Application for a non-material amendment following a grant of planning permission, Town and Country Planning Act 1990

Non material amendment to previous permission 2016/92172 for erection of single storey rear extension

152, Hartshead Lane, Hartshead, Liversedge, WF15 8AJ

Application Number: 2016/94052

D/16/42/1

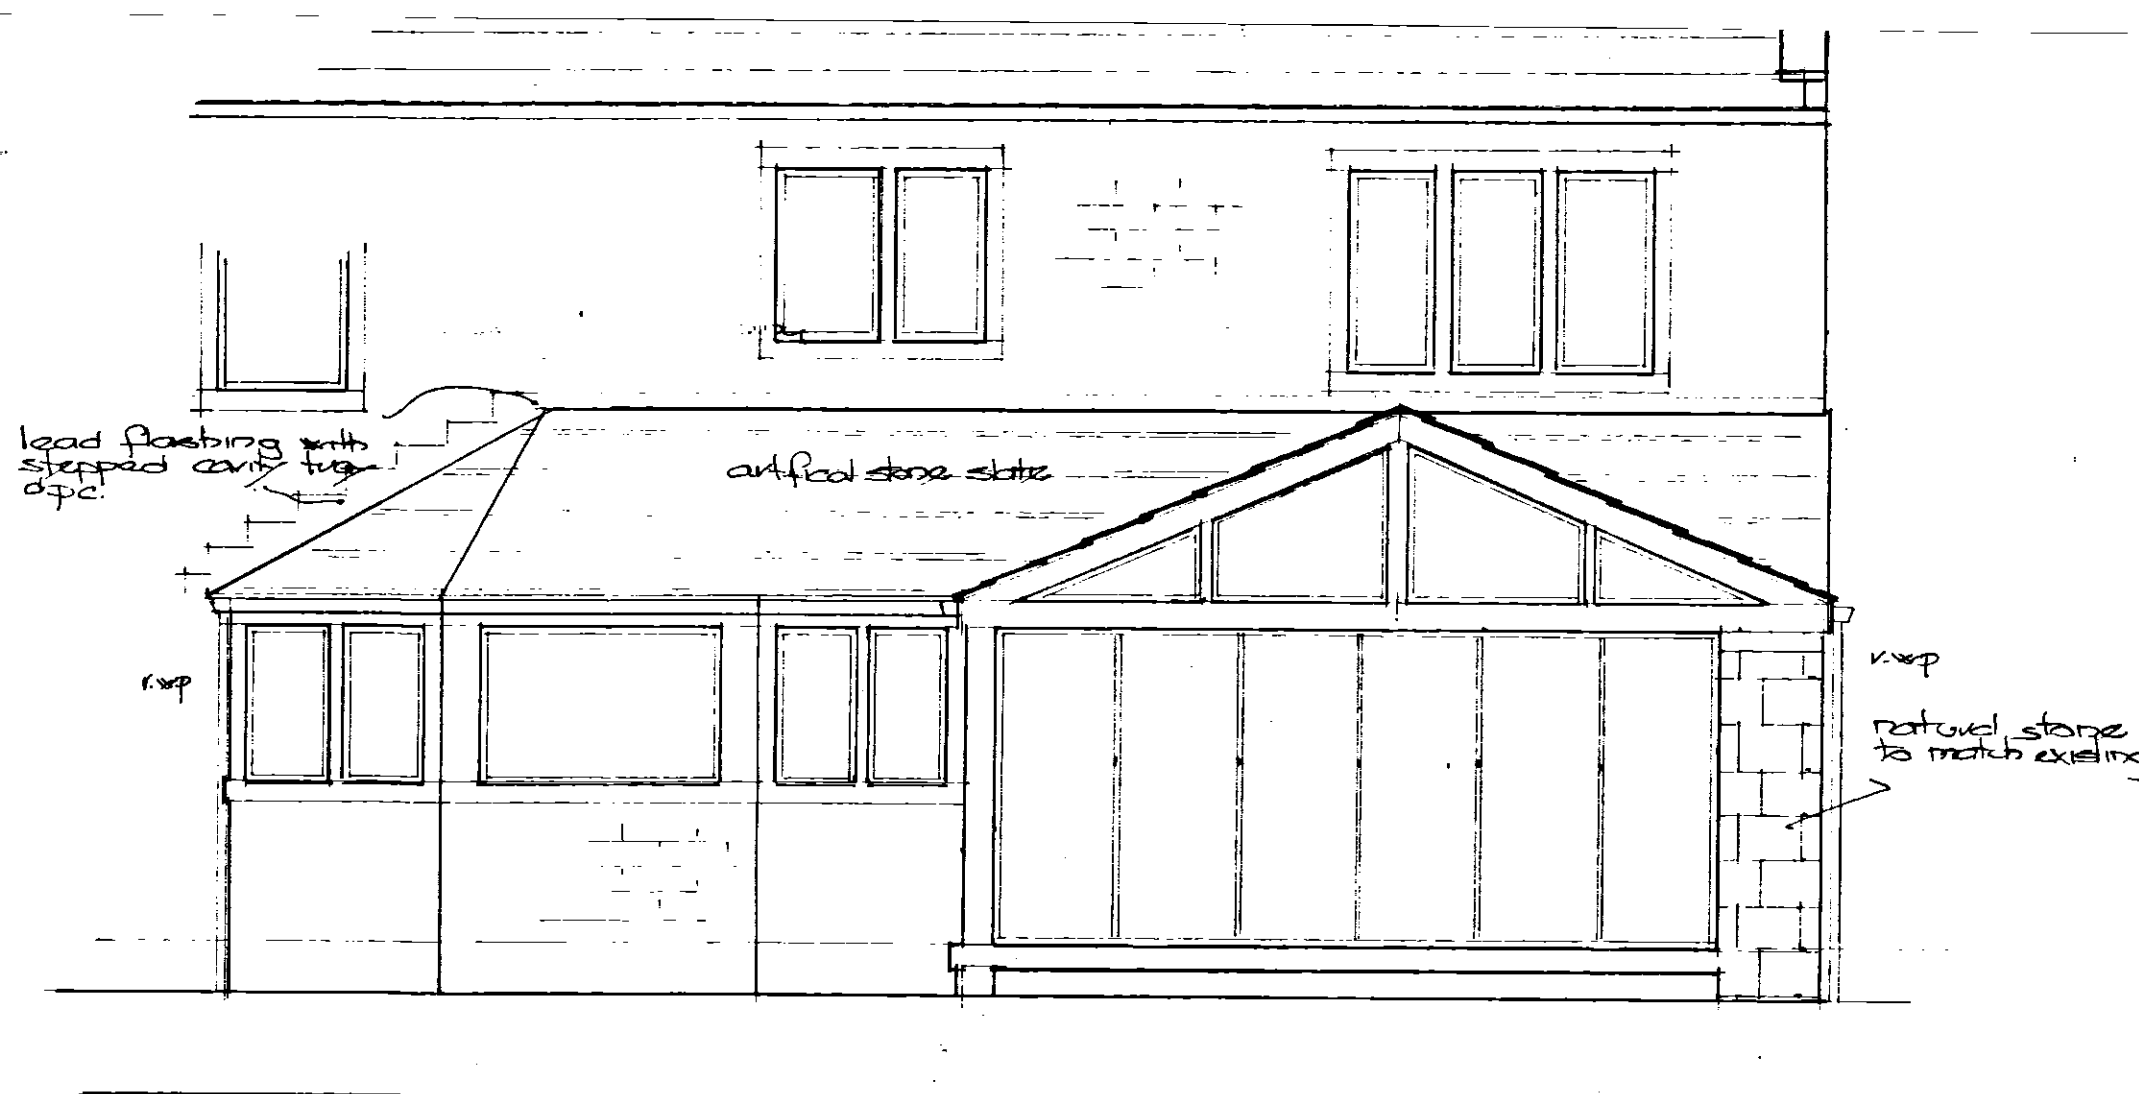
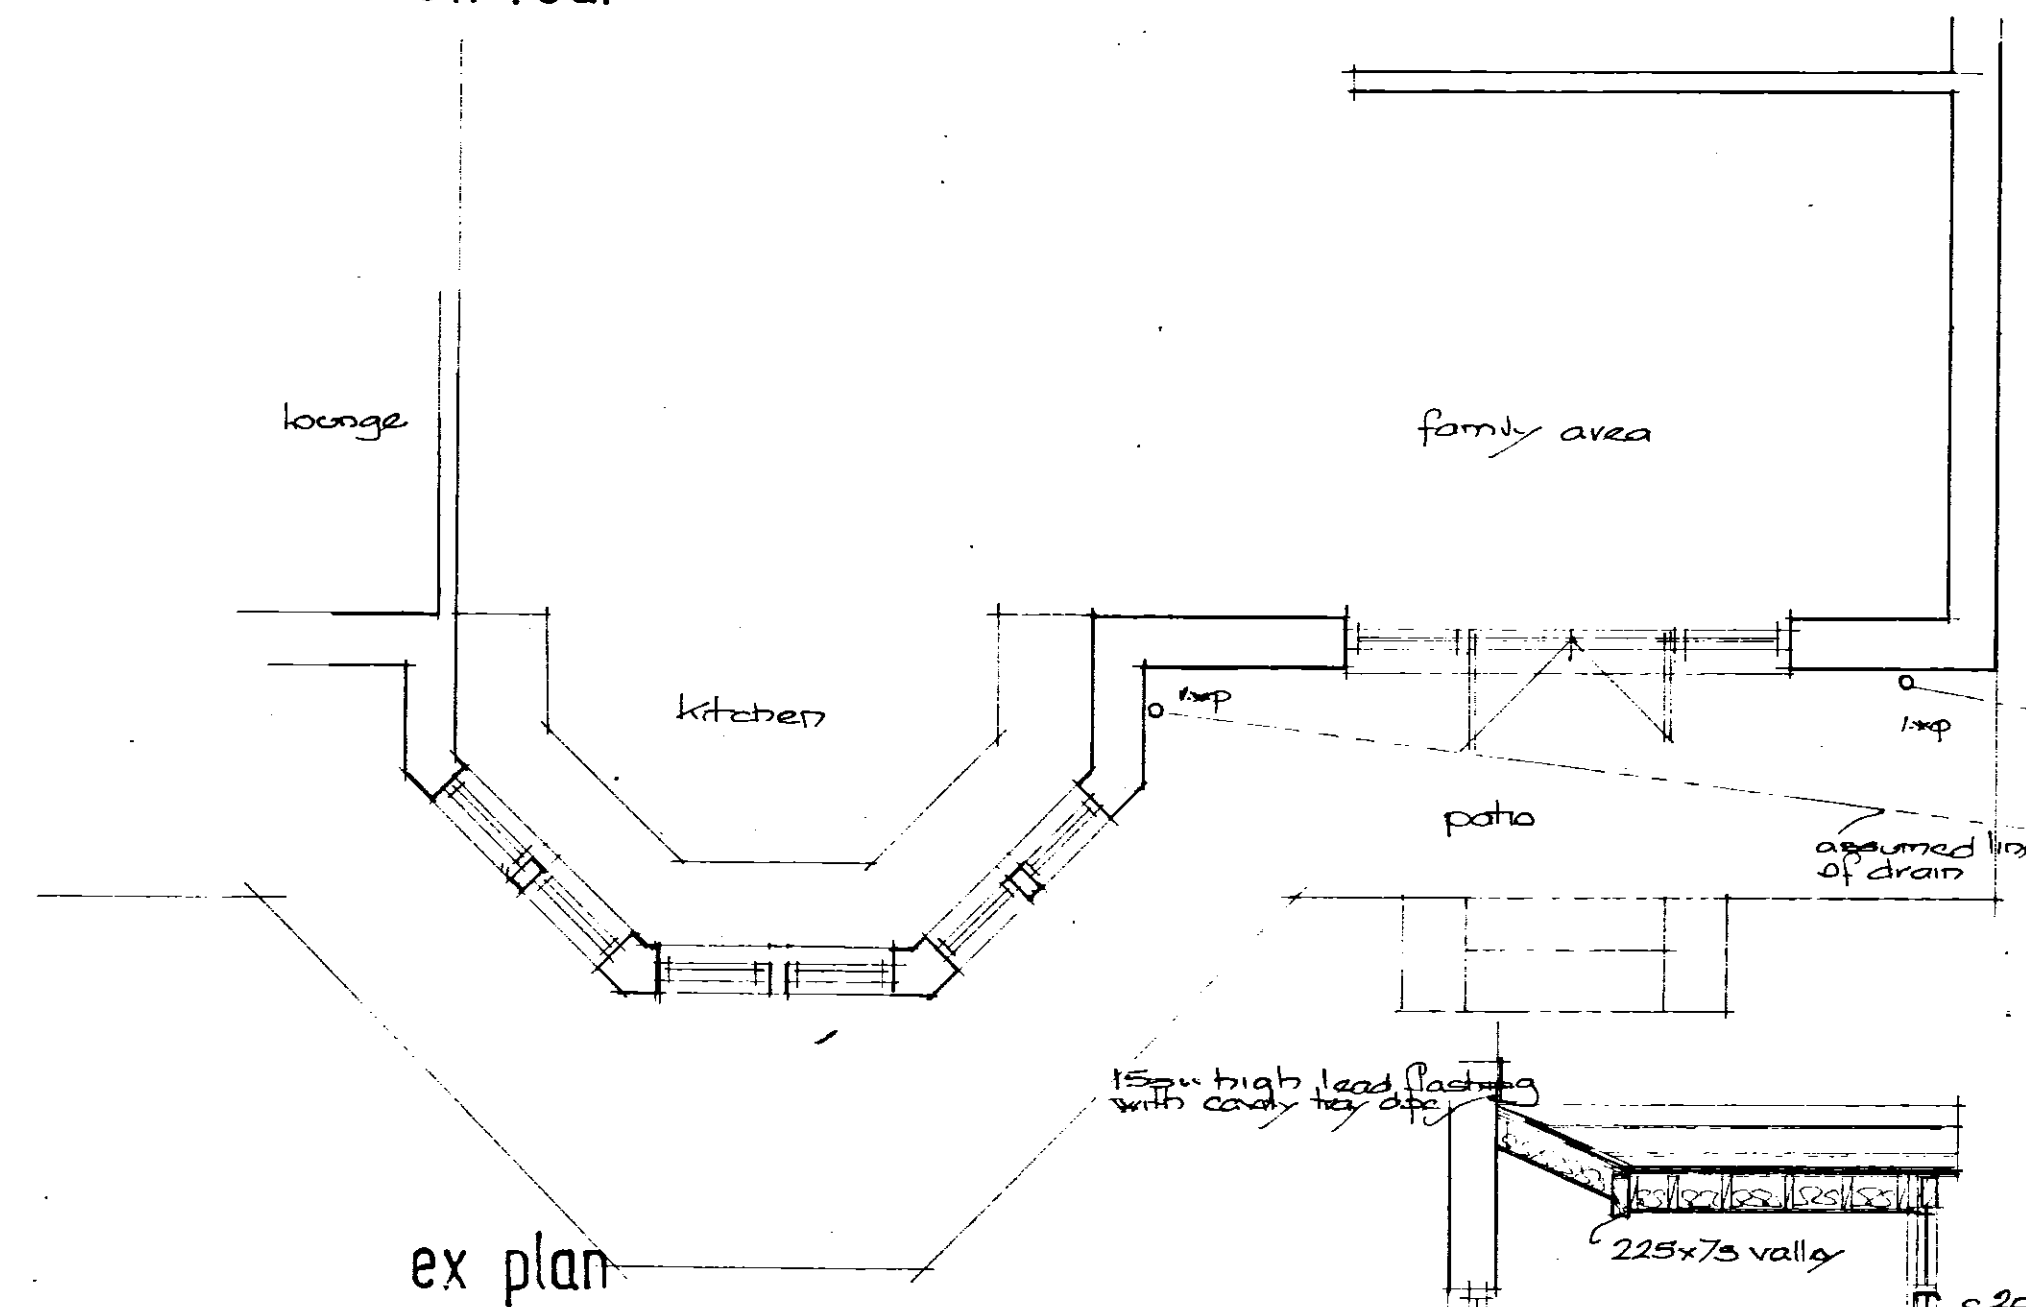
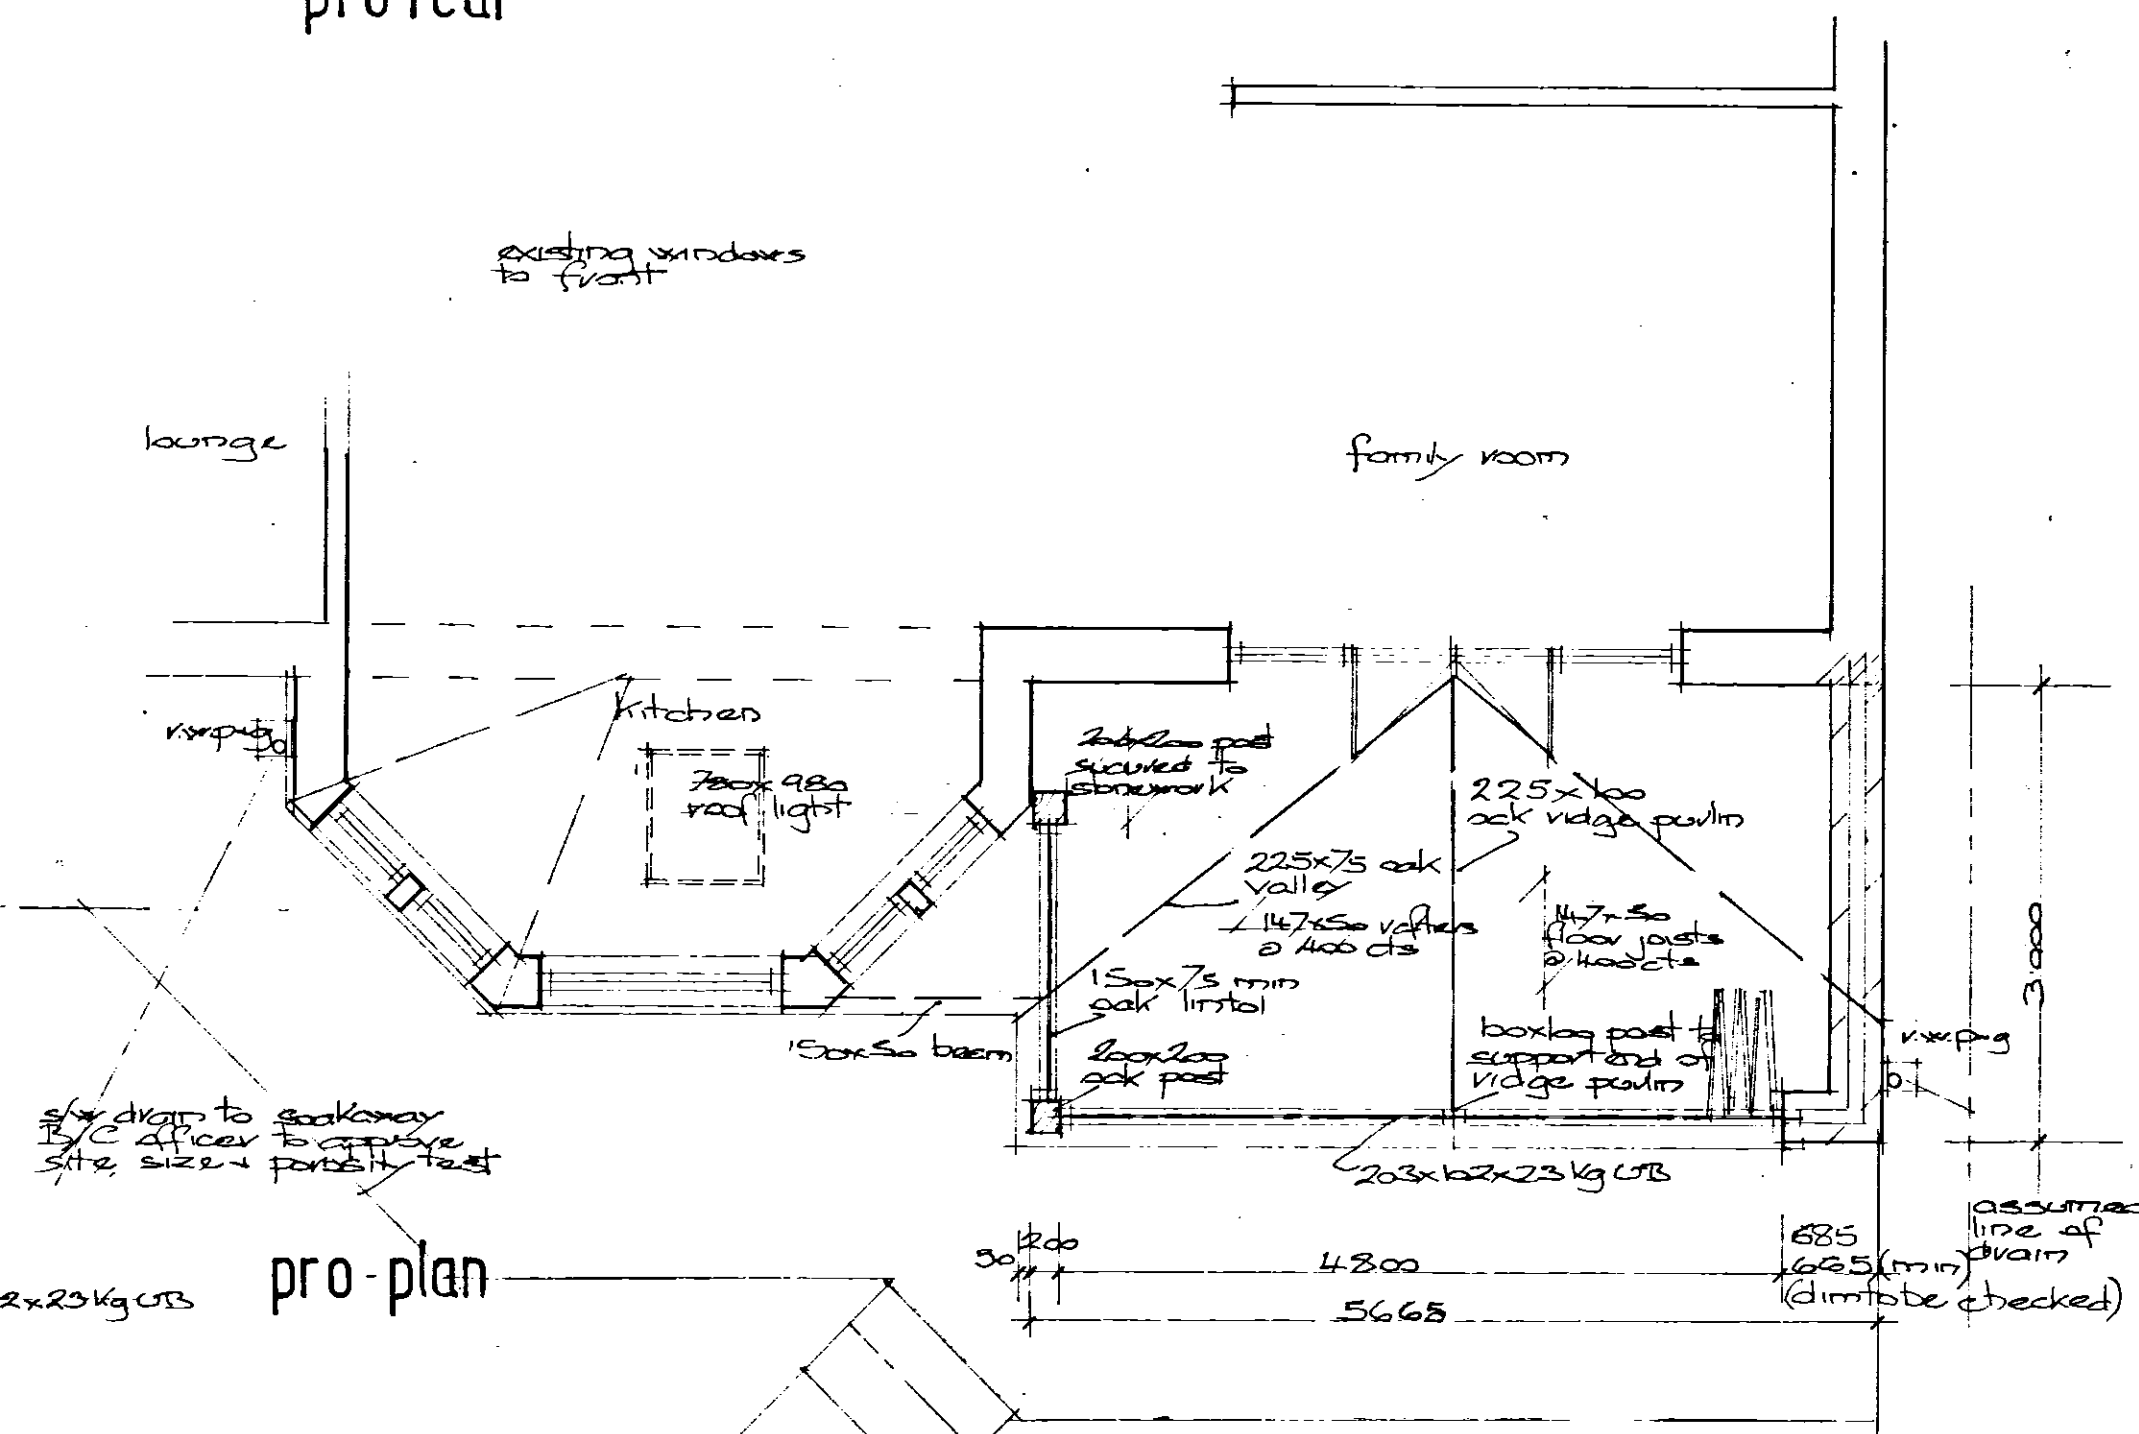
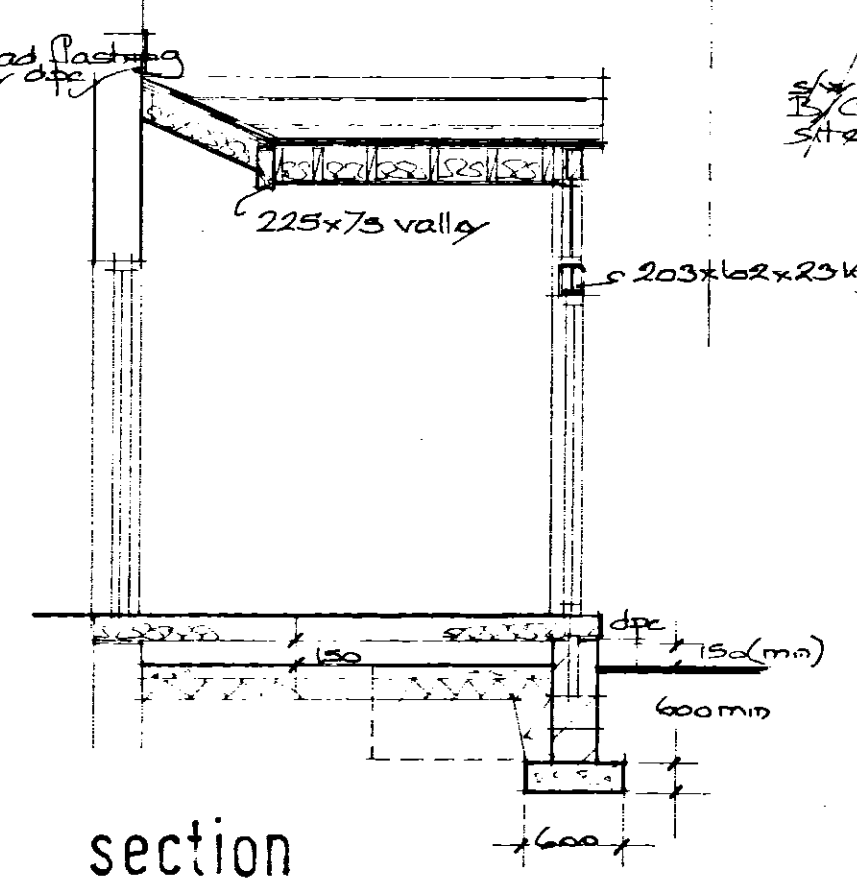
Thank you for your application dated 30th November 2016 for a non-material amendment to planning permission 2016/92172. The amendment sought is to change the design of the rear extension as seen on proposed plans (D/16/42/1). The size of the extension would not increase.

I confirm that the alterations are acceptable and may be considered as a non-material amendment to the approved drawings. It should be noted that this letter relates only to the non-material amendment sought and it is not a re-issue of the original planning permission. The two documents should be read together and as such, all conditions imposed on the original granting of planning permission apply to the proposal as now amended. A copy of this letter and the amended plans will be retained on the public record of approved documents.
